From: Ella Pope [REDACTED]
Sent: 14 July 2017 09:10
To: Simon Davis
Subject: RE: BR/153/17/RES - 3 Southdown Road

From: Simon Davis
Sent: 12 July 2017 16:30
To: [REDACTED]
Subject: BR/153/17/RES - 3 Southdown Road

SIDE EAST ELEVATION SCALE 1:100

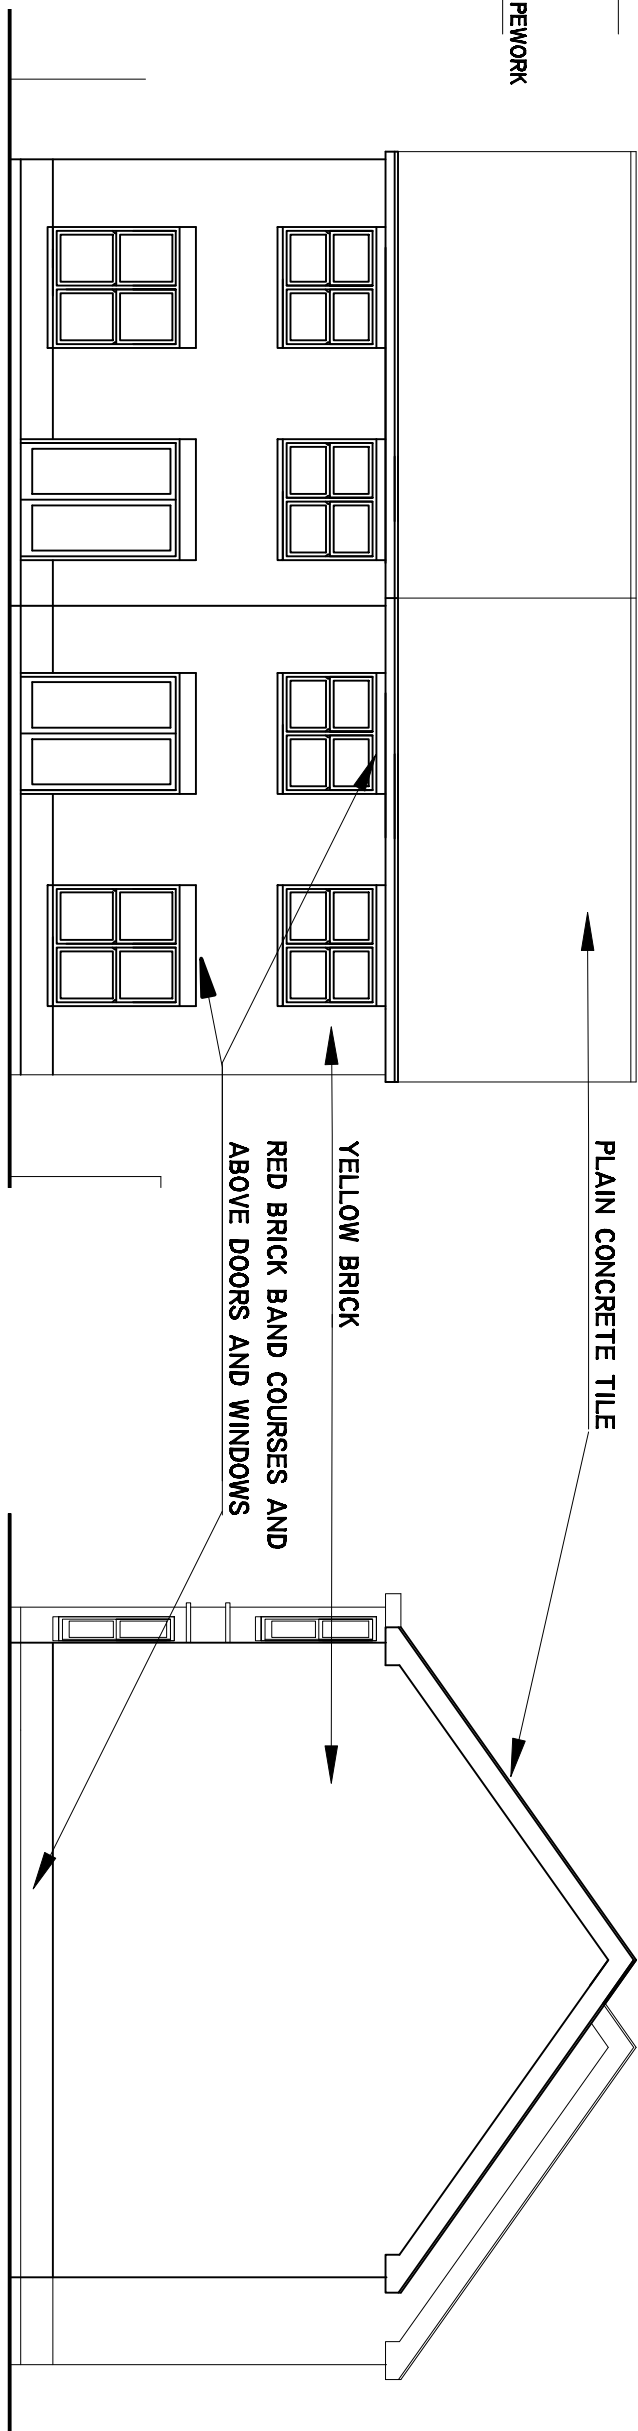
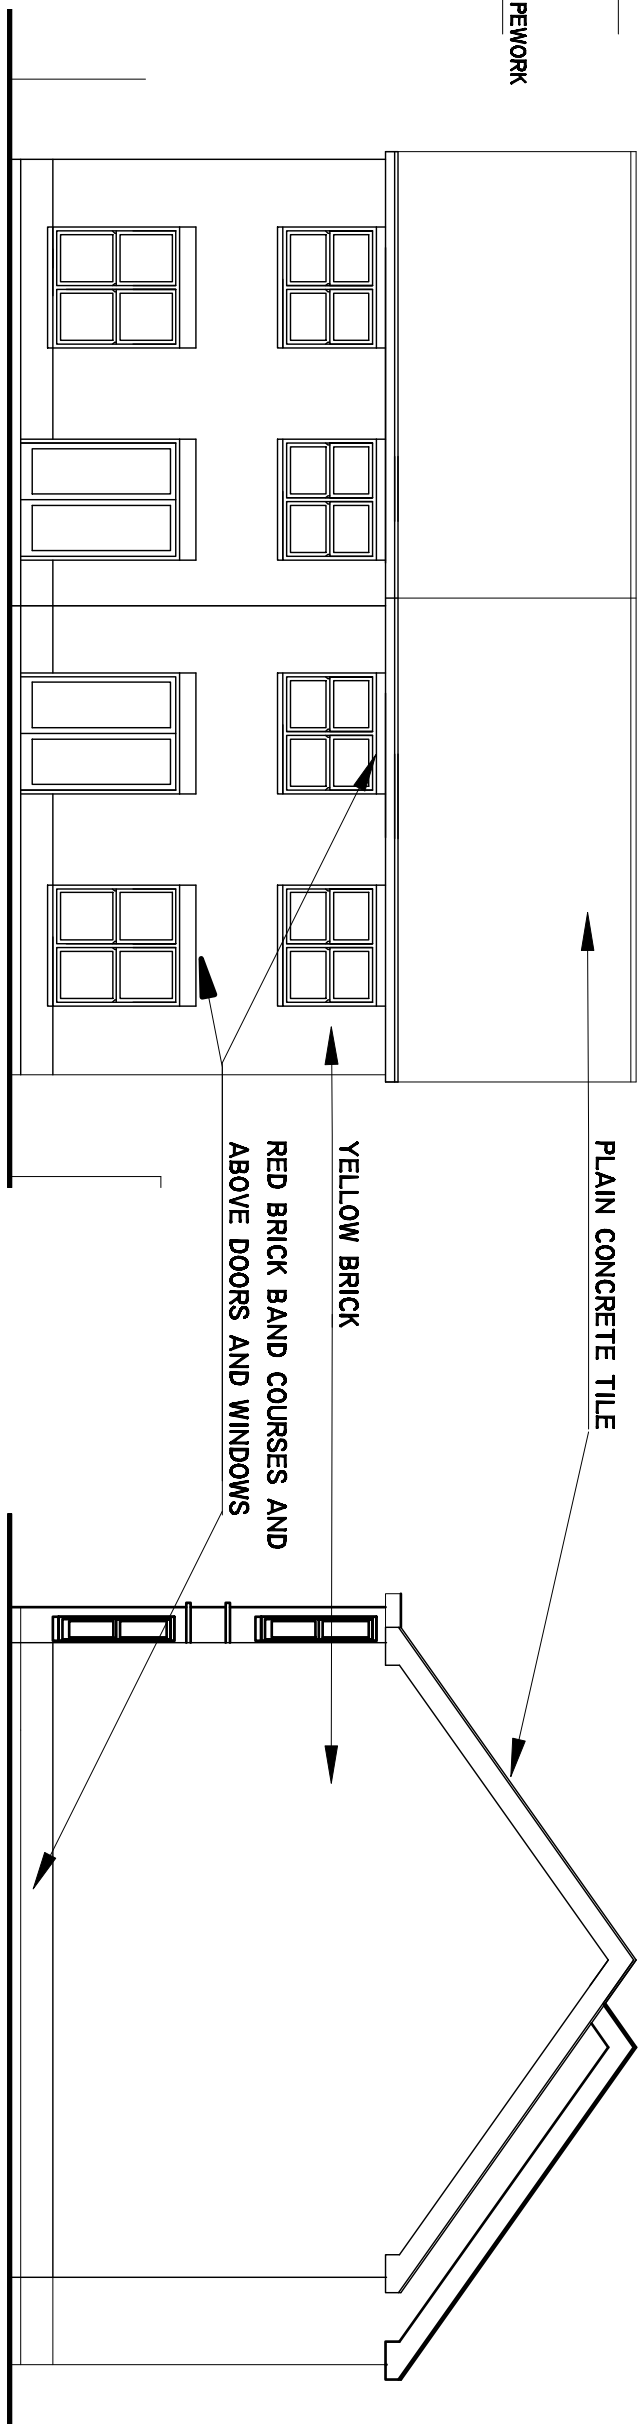
"The original submission showed bay windows to the ground floor but flat or flush windows to the first floor. This application shows bay windows to both floors on the front elevation This would result in a total loss of privacy in our

back garden. I do not see that the upper bay windows are necessary from an aesthetic perspective but they would represent an unjustifiable intrusion into our privacy and enjoyment."

I will accept the FF bay window in the eastern dwelling but only if the two windows in the side panel of the bay (which looks out across 18's rear garden) has obscure glazed windows. I can condition this but I would prefer it if you submit an amended drawing reflecting this please.

Thank you for your message. Further to consulting with the Client, please find attached a revised drawing as requested, showing the 2 no. window panes of the first floor bay window facing east to be obscure, thank you. We trust we have interpreted your requirements correctly.
Should you require any further information please do not hesitate to contact us.
